Our ref: NO/2021/113750/01-L01
Your ref: 3/2021/0731
Date: 16 August 2021

REDEVELOPMENT OF THE EXISTING EDUCATIONAL FACILITY INCLUDING PART DEMOLITION OF THE EXISTING INFANT SCHOOL TO PROVIDE A STANDALONE NURSERY FACILITY, TOGETHER WITH THE REMODELLING OF, AND EXTENSION TO, THE EXISTING JUNIOR SCHOOL, AND ERECTION OF A NEW INFANT BLOCK TO THE REAR OF THE BUILDING, ALONGSIDE ADDITIONAL CAR PARKING. SOFT AND HARD LANDSCAPING TREATMENT AND VEHICULAR ACCESS WORKS OFF GREENACRE STREET. ST JAMES C OF E PRIMARY SCHOOL, GREENACRE STREET, CLITHEROE, BB7 1ED.

Environment Agency position

Figure 3 - Location of Infant Block and 2D Levels

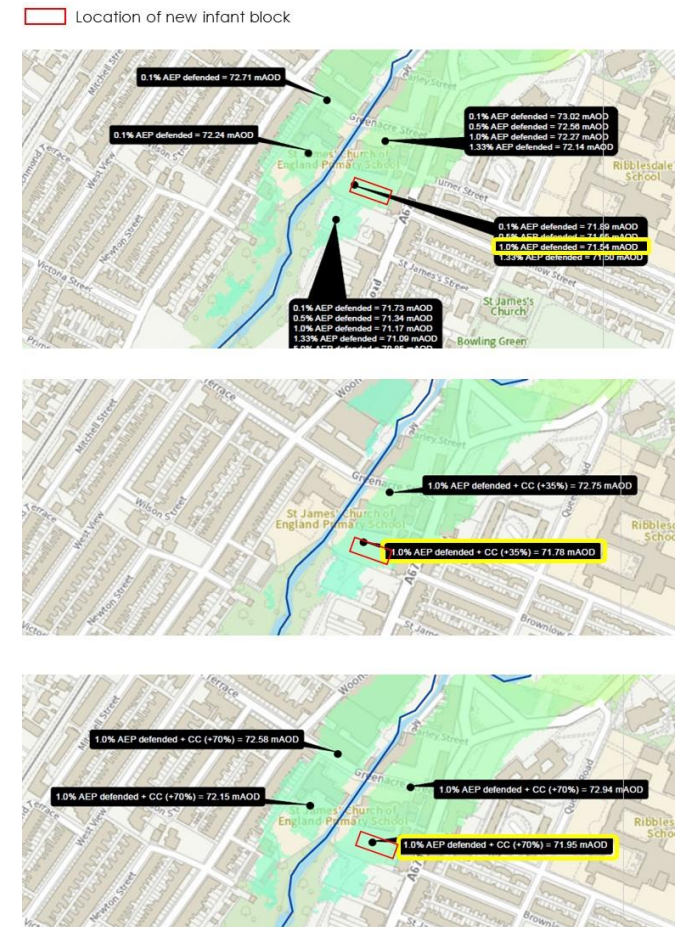
- The finished floor levels (FFL) should be set 600 mm above the Q100 plus Climate change (CC) allowance level, this should be the higher level of either the defended or undefended levels, unless adequate justification can be provided. At present, the FFL of 72.32m is not 600mm higher than the undefended Q100 level (this has not accounted for an allowance for climate change).

To overcome our objection, the applicant should submit a revised FRA and plan which addresses the points highlighted above.
